Please see the Drainage Engineer's comments below. I apologise that I have not advised you of their response sooner. Can you let me know how long it is likely to take to provide the additional information requested? If it will be more than a couple of weeks then discharge of this condition may be refused.

Engineers Comments Regarding Surface Water Drainage

Drawing:
Surface water drainage

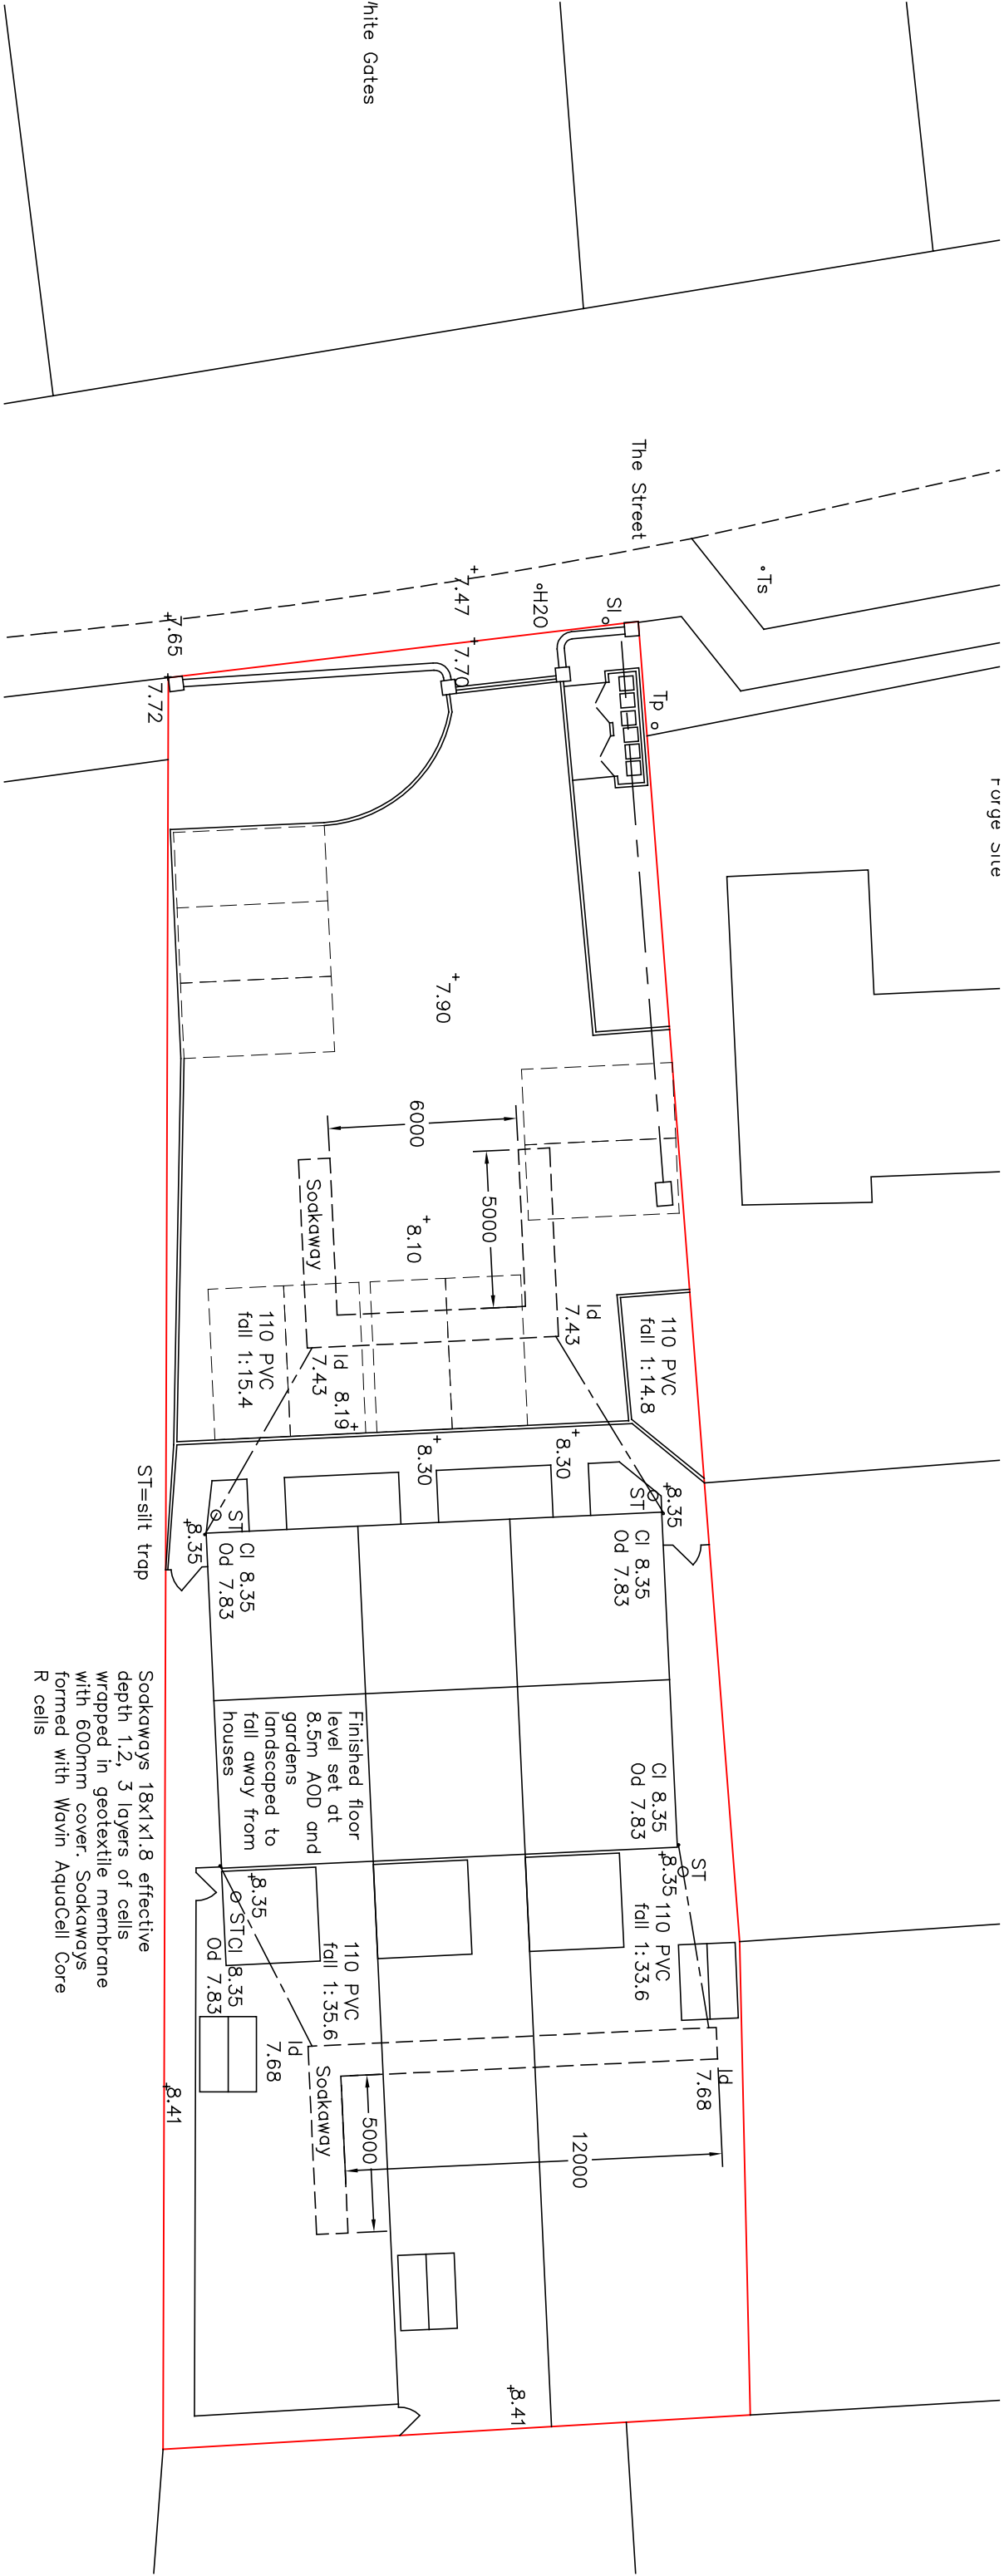
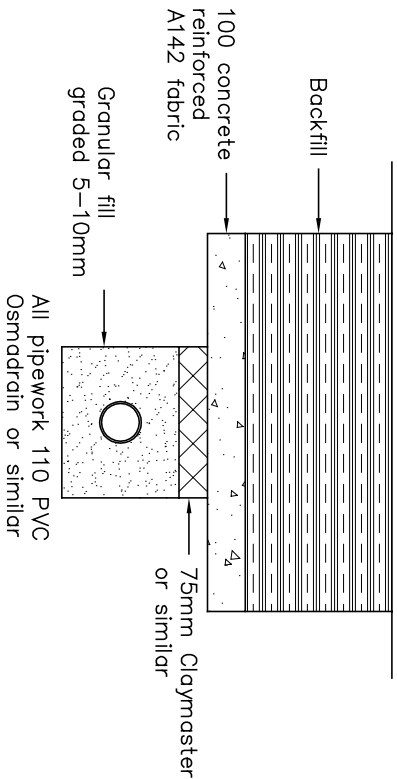
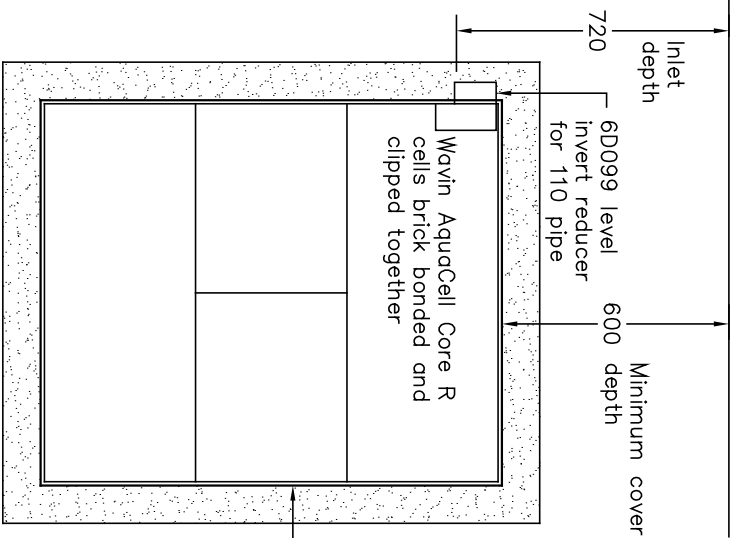
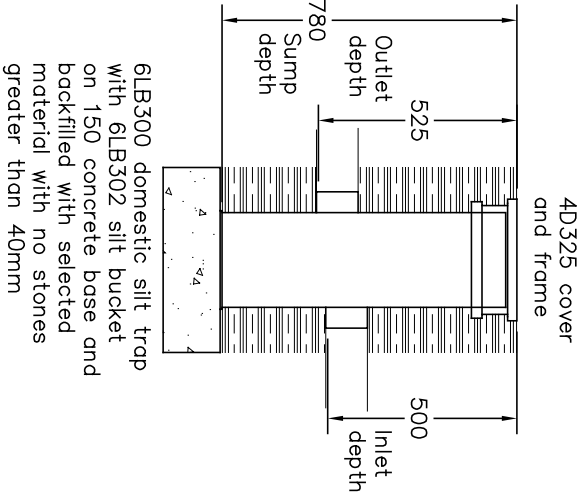
The infiltration rate on the site is very low (1.07×10^{-6}), it is not possible to achieve a half drain time of 24 hours. As a result the agent proposed upsizing the soakaways to hold up to 3x 1 in 100 year storms, allowing for additional inflow whilst the soakaways drained. Whilst the situation is undesirable we agreed that this was a reasonable solution. However, we would need to see an exceedance flow route, or topographical levels that showed that any excess flow (if the soakaways reached capacity or became blocked) would be directed away from the properties. This has not been supplied as part of the application. In addition, the soakaway dimensions described on the plan do not reflect the dimensions on the calculations (which would not meet the criteria discussed).

1. Dimensions of each soakaway (ensure these match the calculations), invert levels and cover levels also need to be labelled. The soakaway crates should be specified and suitable for vehicular loading at the depths proposed.

2. Show all pipes, these should be labelled with diameters, pipe materials, falls and invert levels (at ends).
 3. Location of any manholes/inspection chambers, including their cover levels, invert levels, and cover types.

4. Silt traps which must be included upstream of any connection to a soakaway. Also labelled with invert and cover levels, ideally also sump levels.
2. Supply an exceedance flow route and/or topographical levels that show that any exceedance flow will be directed away from any buildings.

3. Supply construction detail drawings for all components:
 1. Soakaways
 2. Pipe bed and surrounds
 3. Manholes/inspection chambers
 4. Silt traps
 4. Amend and submit calculations to reflect the soakaways specified.
